MECKLENBURG COUNTY
Park and Recreation Department

MEMORANDUM

DATE: September 22, 2021

RE: Rezoning Petition #2021-119 – Profile Freedom Drive

SHEET NUMBER
RZ-1

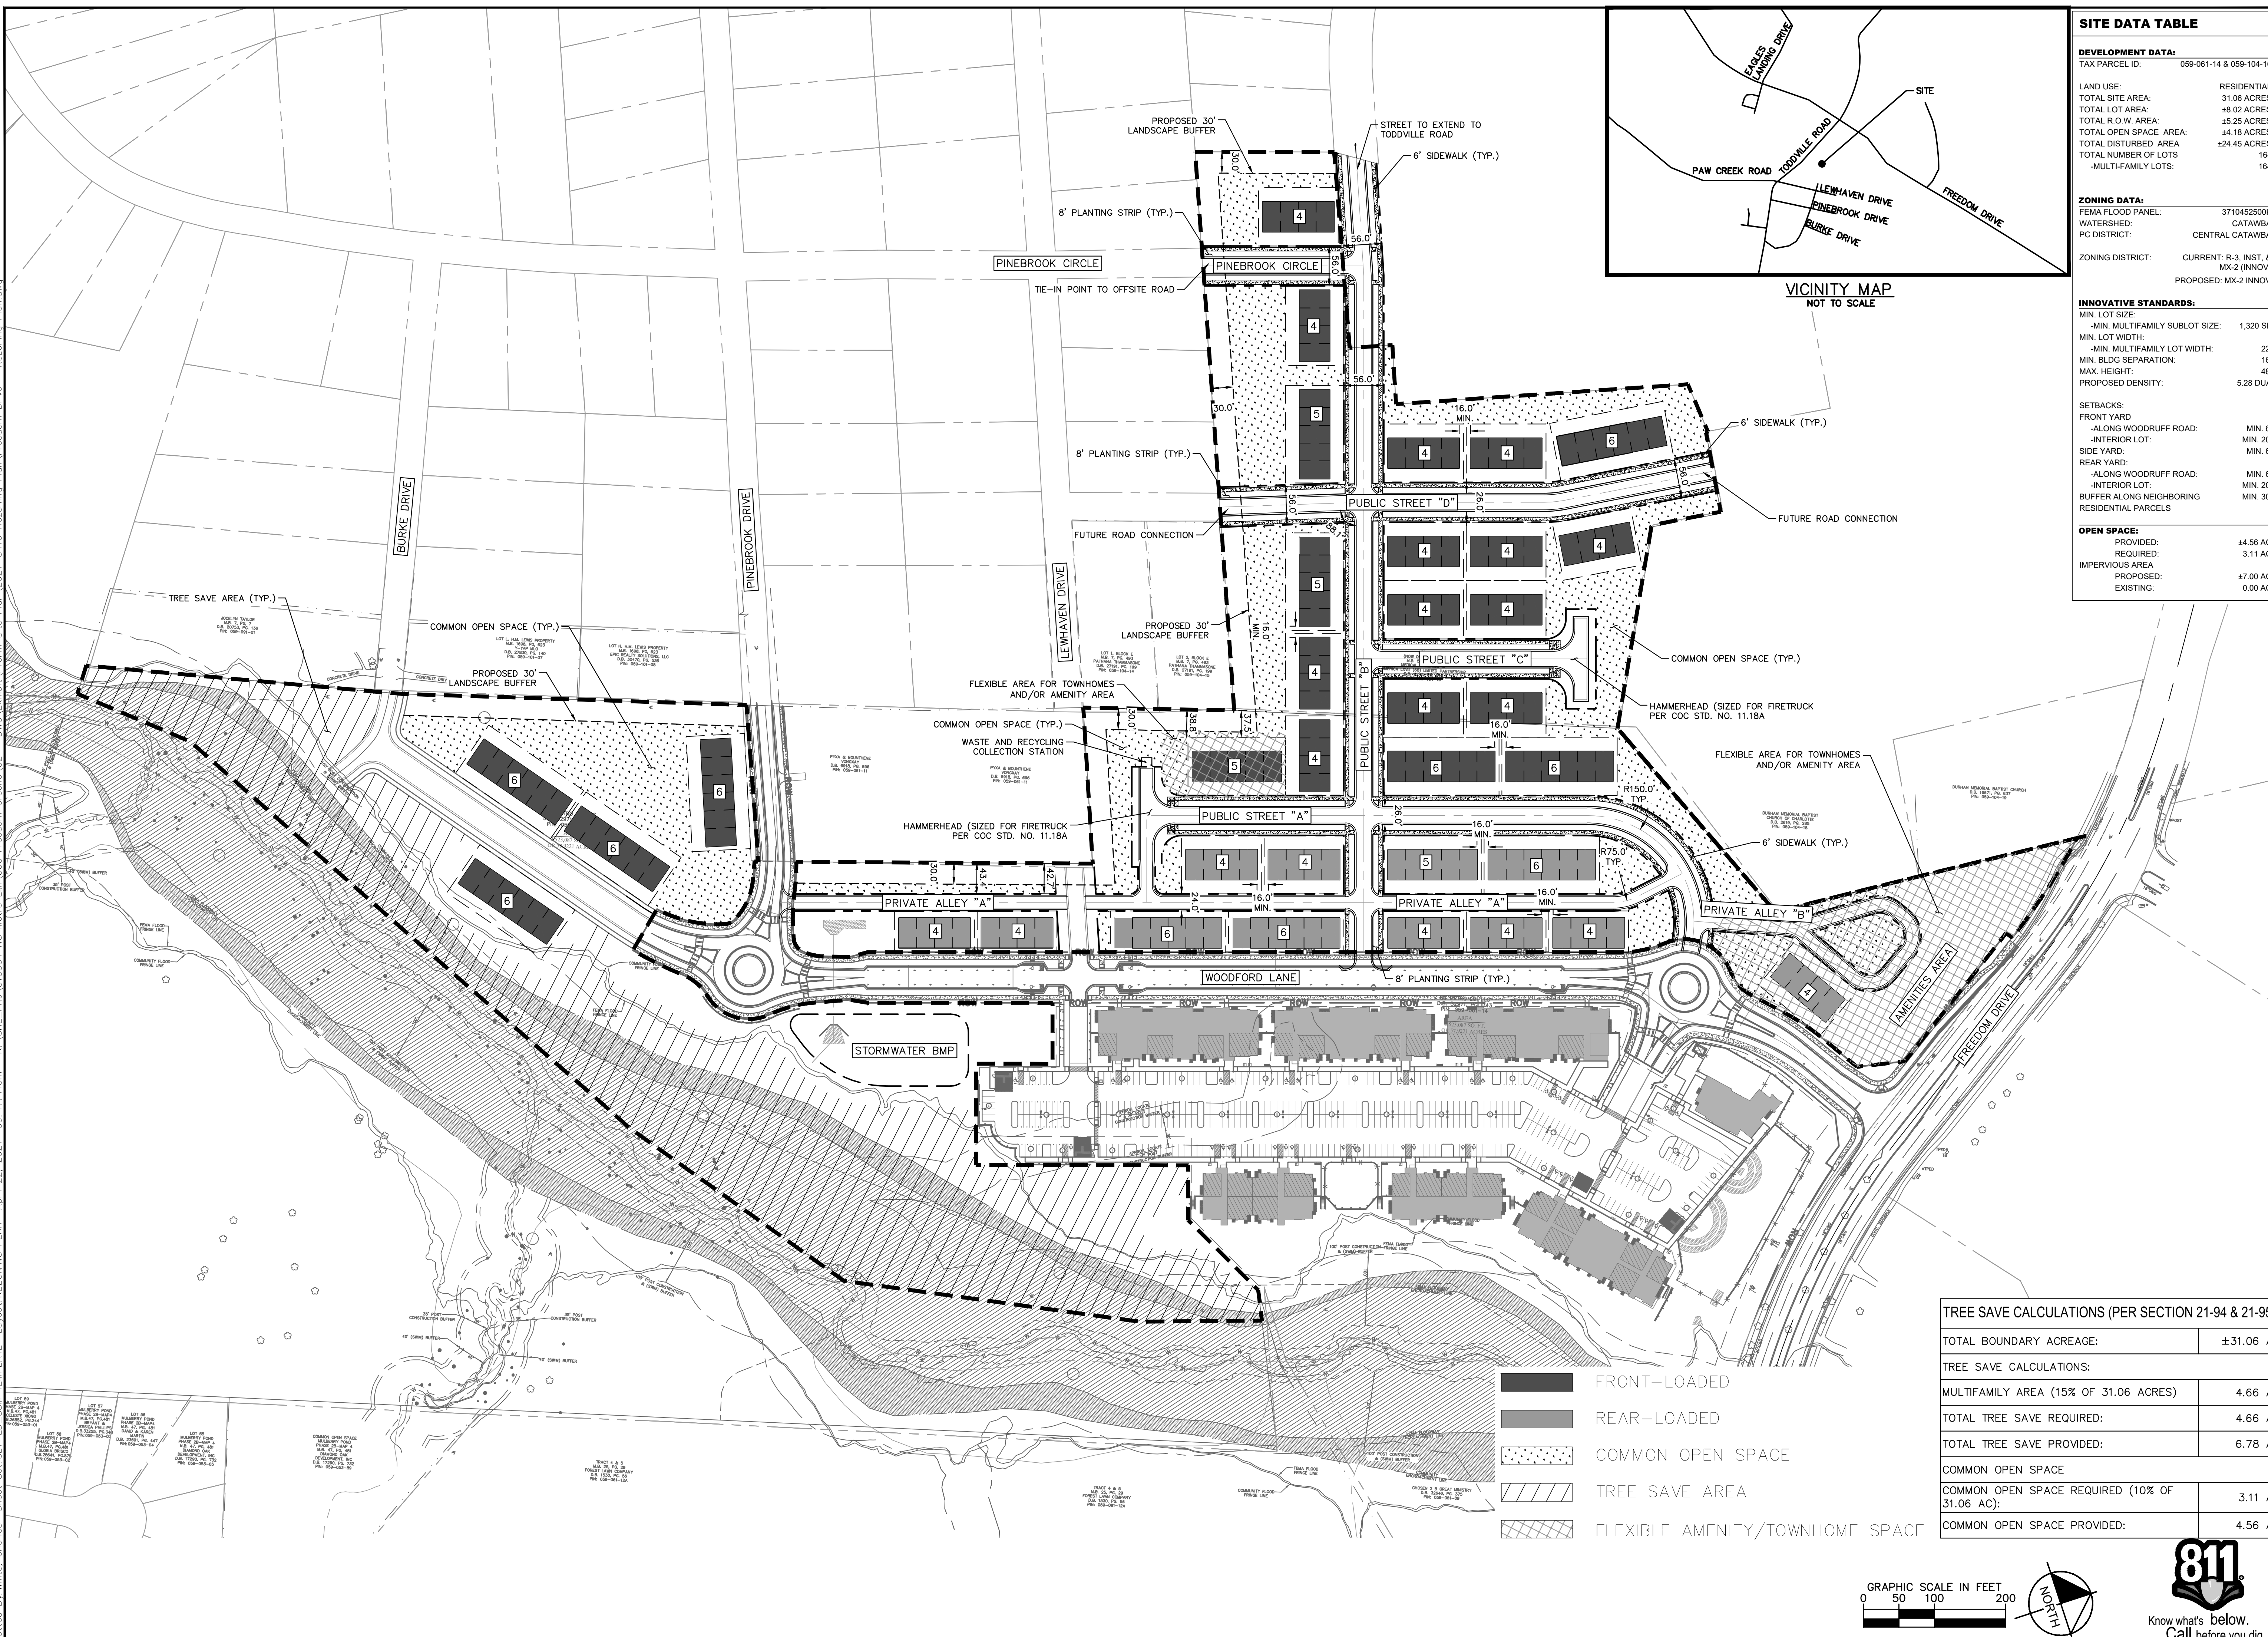
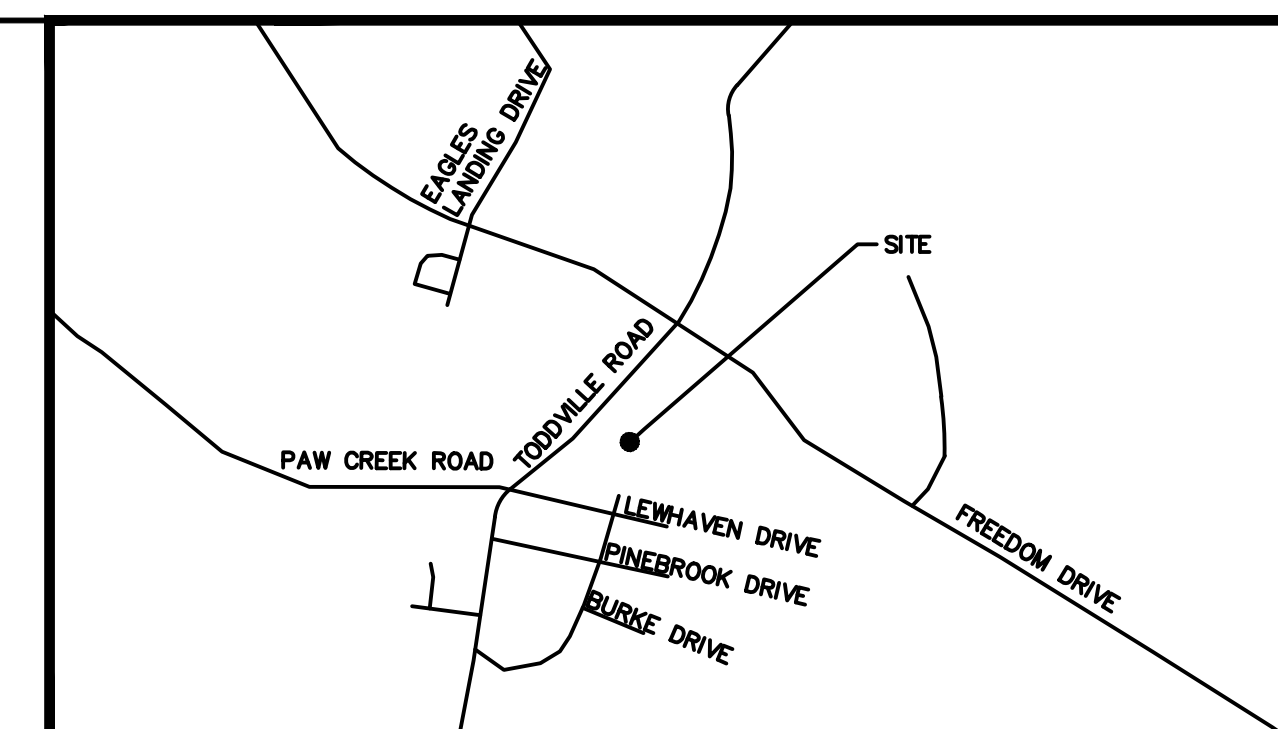
In coordination with previous rezoning petitions and ongoing email communication with the development team on the property, MCPR requests the petitioner dedicate and convey or provide a greenway and storm water easement of the same area to Mecklenburg County - the 100' SWIM Buffer and the FEMA floodplain of Paw Creek. Additionally, MCPR requests a minimum of 100' wide easement between the dedicated greenway parcel/easement and the Woodford Lane ROW. Trail dedication can overlap with tree save areas. This parcel is on the MCPR Greenway Master Plan. Contact MCPR with any questions/comments.
